Please ask for: Mrs D Johnson
Email: daun.johnson@arun.gov.uk
Telephone: 01903 737762
Our Ref: A/45/22/PL
Your Ref:
Date: 22nd March 2022

Application for Planning Permission

Development: Erection of 167 No new homes in a mix of 1-4 bedroom properties (2-4 bedroom homes and 1 bedroom apartments), with associated landscaping, parking, open space, play areas, construction of a new vehicular access from Golfers Lane and all other associated development works (resubmission following A/129/21/PL). This application is a Departure from the Development Plan and is in CIL Zone 3 and is CIL Liable as new dwellings.

Location: Rustington Golf Centre Golfers Lane Angmering BN16 4NB

Rear Elevation
The Spine

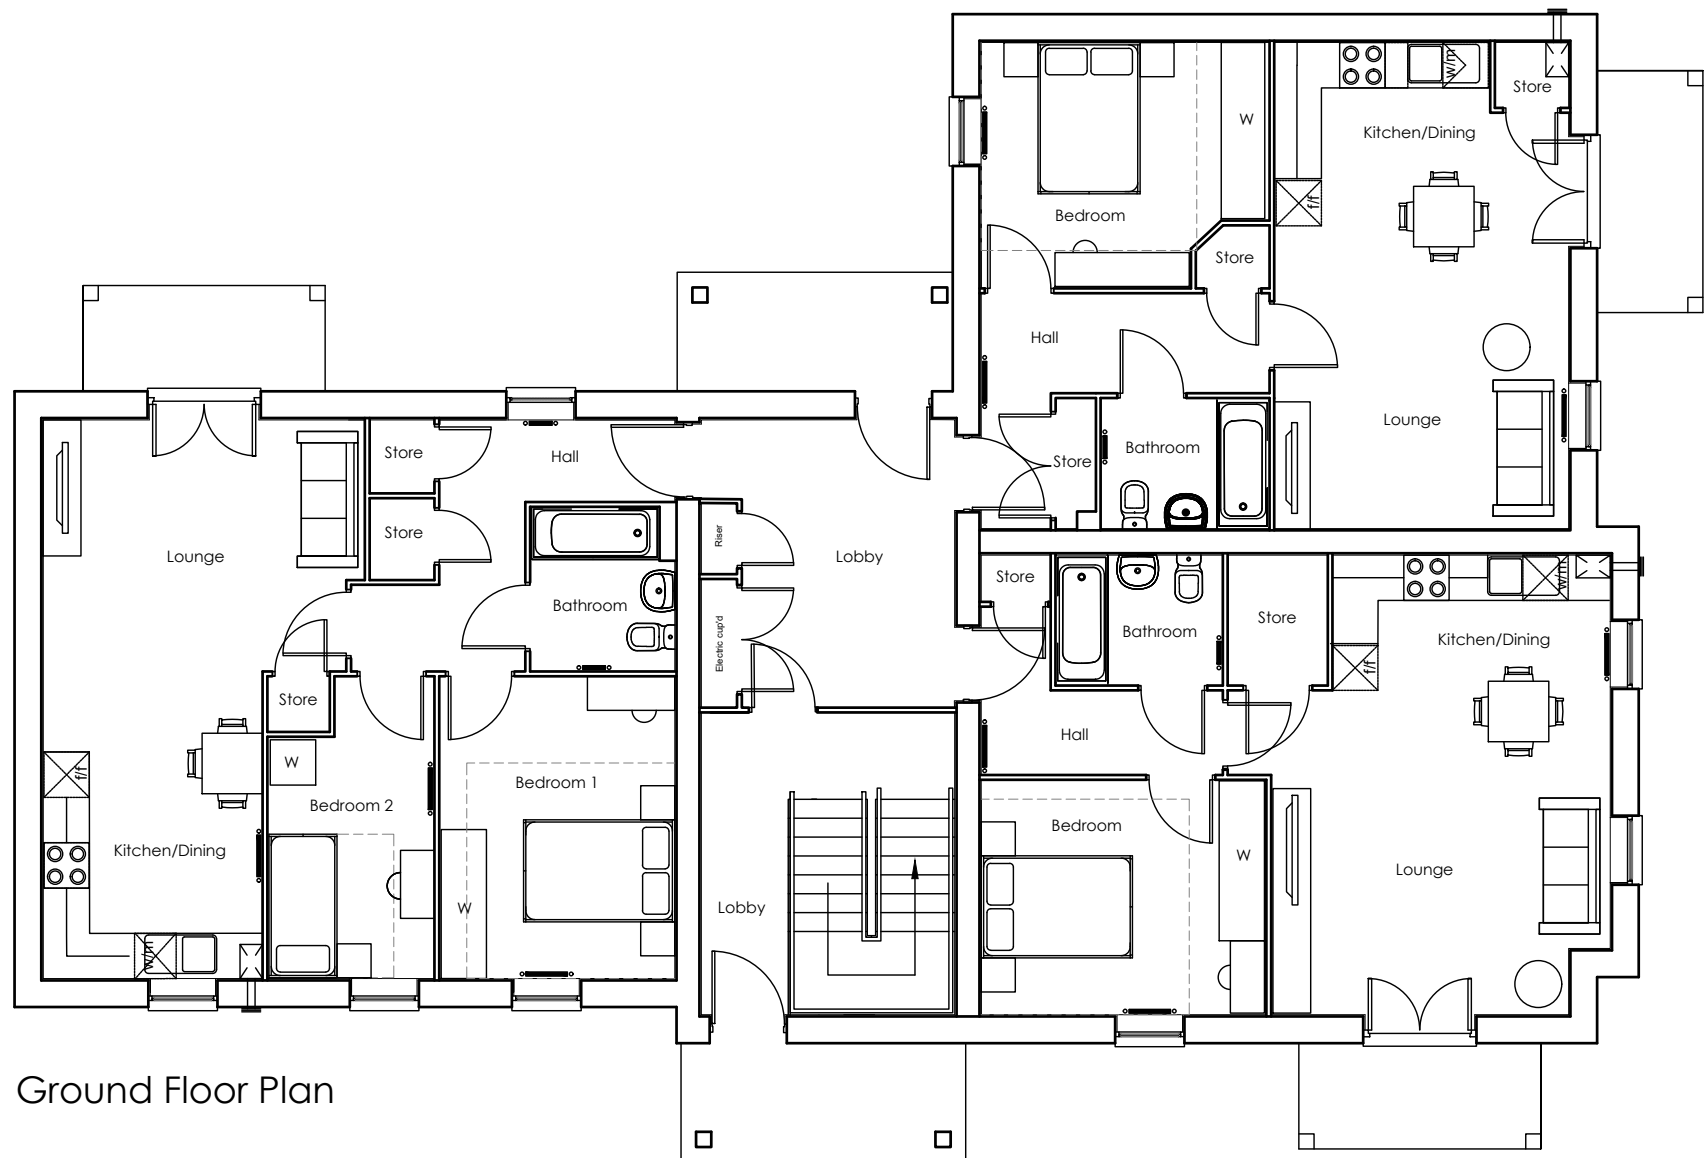
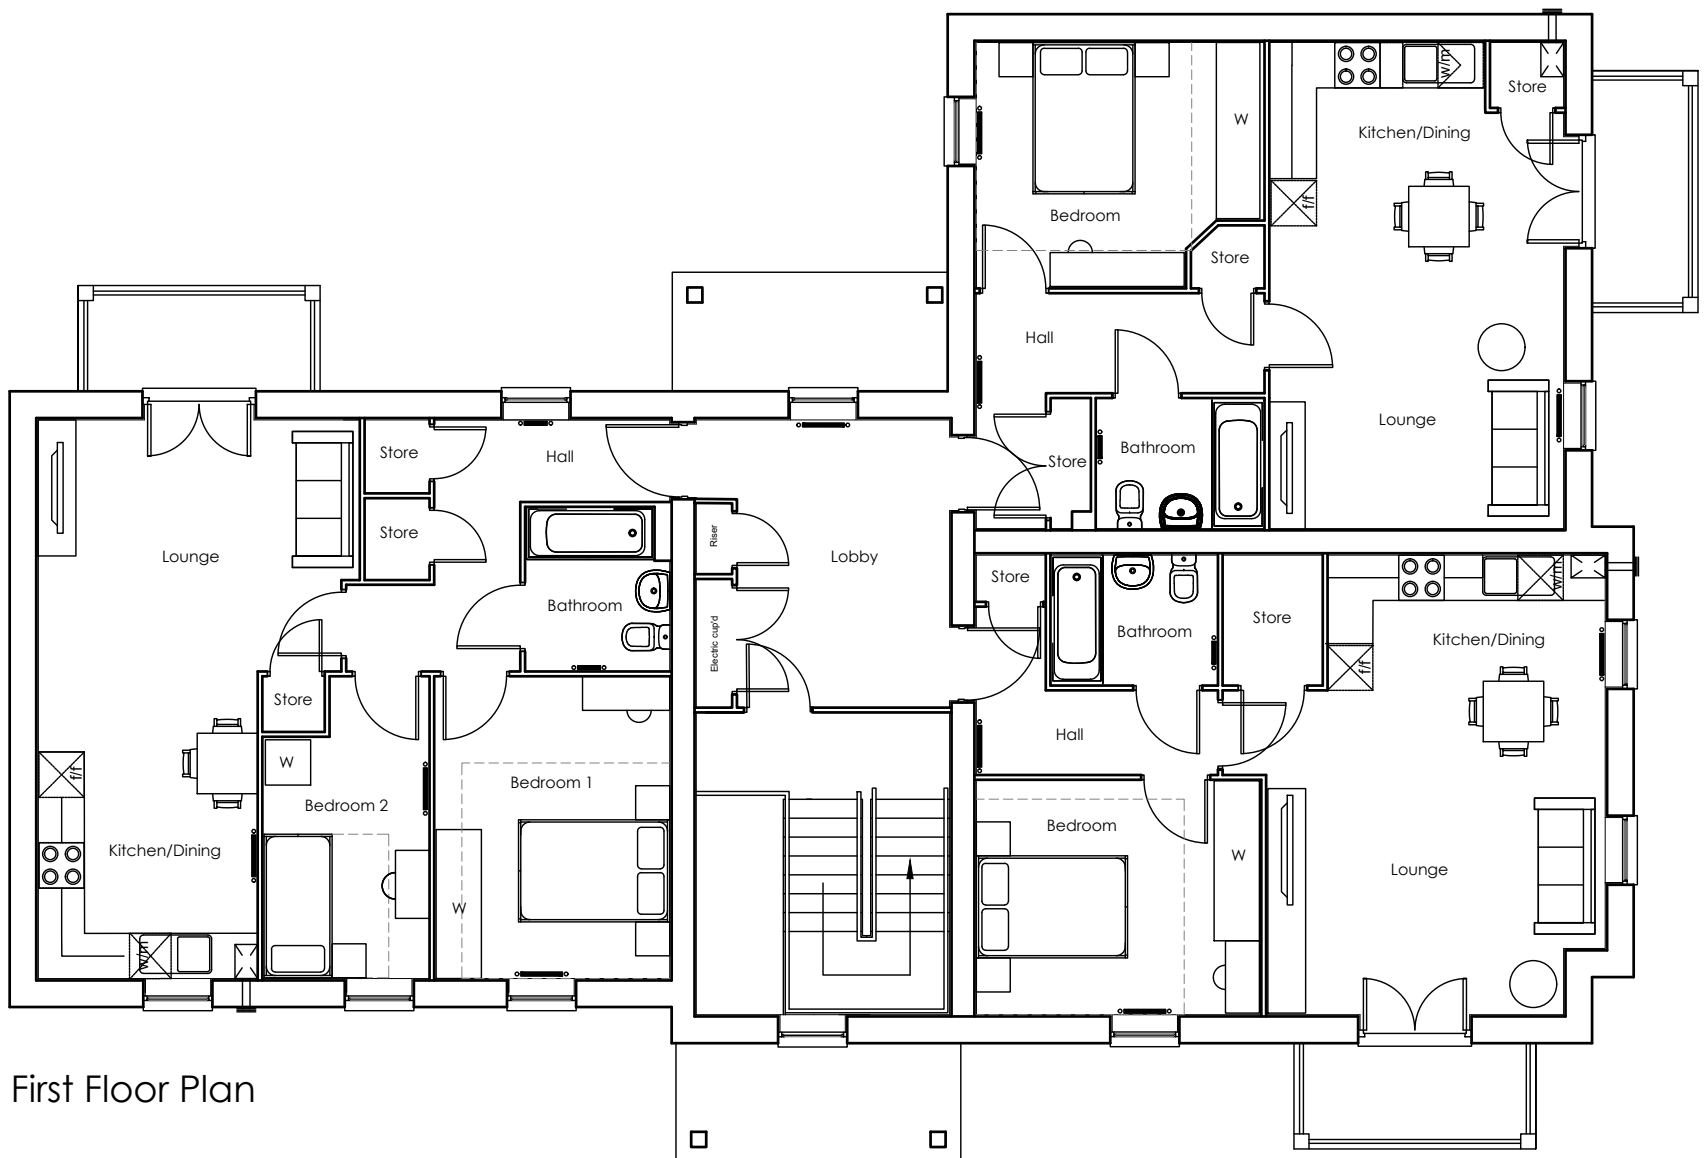
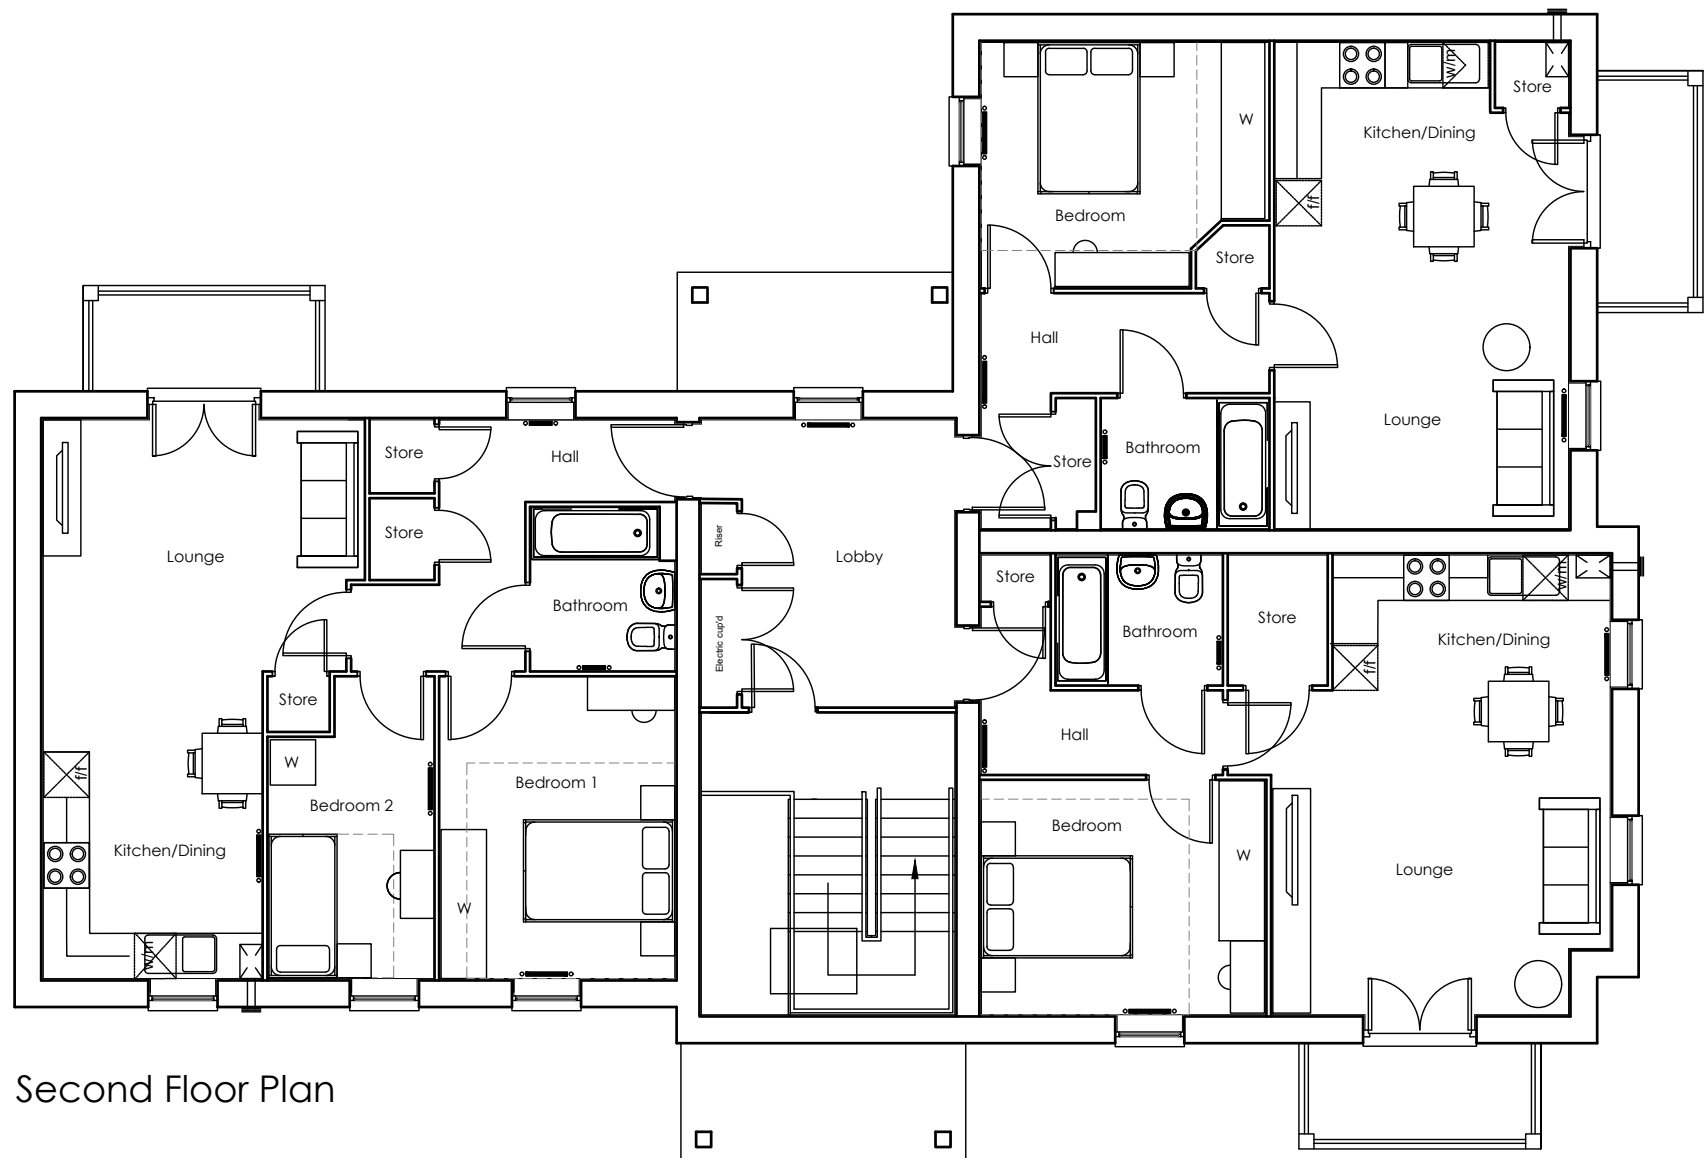
On plan PLN-1-3400 Rev A, please provide a second floor plan and the ground, first and second floor plans and rear elevation do not accord. Please amend accordingly.
